STATE OF NORTH CAROLINA DEPARTMENT OF TRANSPORTATION

Addendum No. 1

RE: Contract # C204140 WBS # 2018CPT.09.01.10291.1, etc. State Funded Davidson and Forsyth Counties

2 SECTIONS OF NC-65, 1 SECTION OF NC-150, NC-66, AND NC-67, AND 12 SECTIONS OF SECONDARY ROADS.

Map 21
 Davidson County
 NC 150 Peters Creek Parkway North/South Bound
 Mill 1½" depth Pave back 1½" S9.5C
 ALL WORK ON THIS MAP TO BE
 DAYTIME ONLY

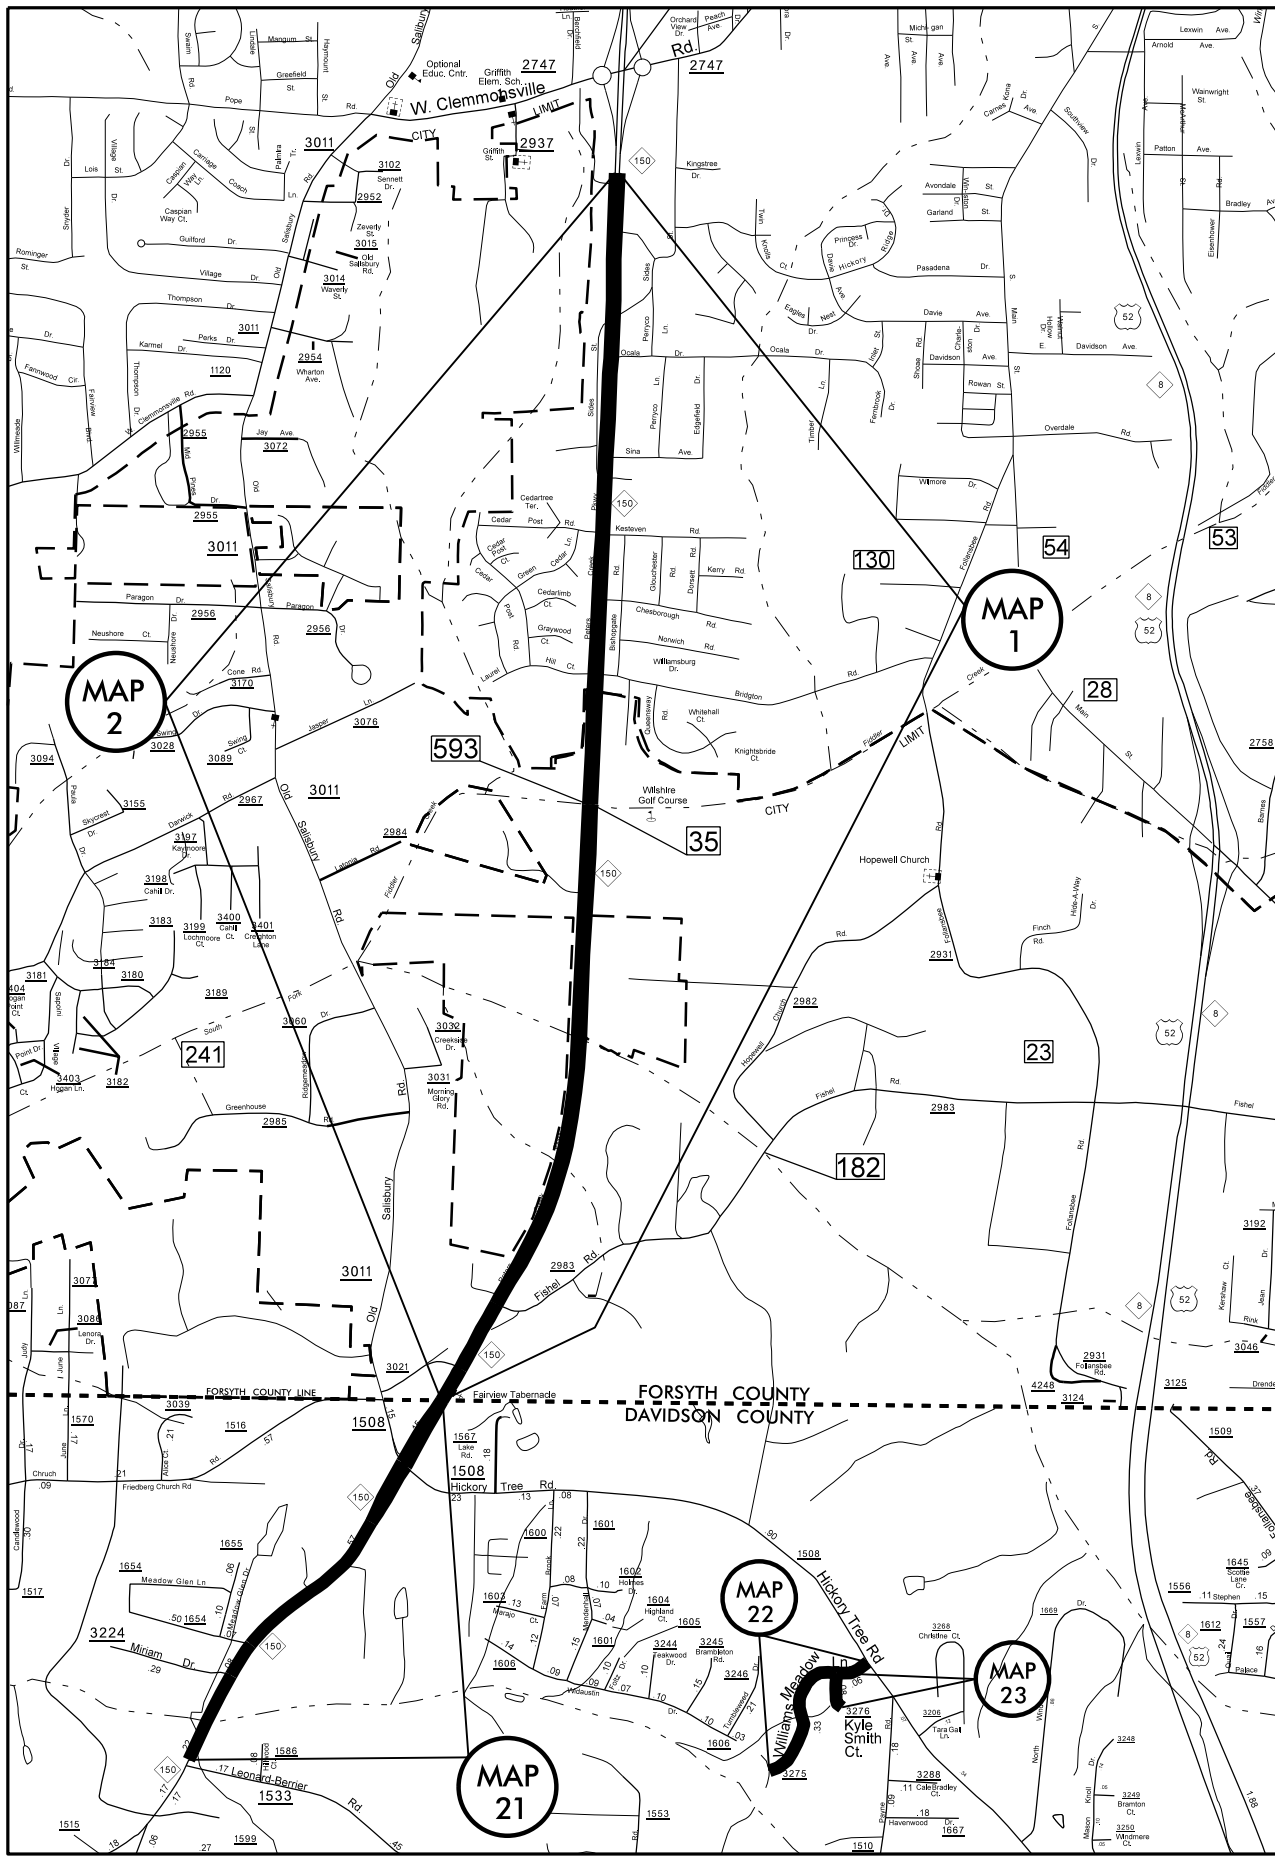
Page No.	Revisions
Proposal Cover	Note added that reads "Includes Addendum No. 1 Dated 03-13-2018".
G-2	Project special provision entitled "INTERMEDIATE CONTRACT TIME NUMBER 2 AND LIQUIDATED DAMAGES" has been revised

> Map #21 Monday thru Sunday, 7:00 p.m. to 9:00 a.m.
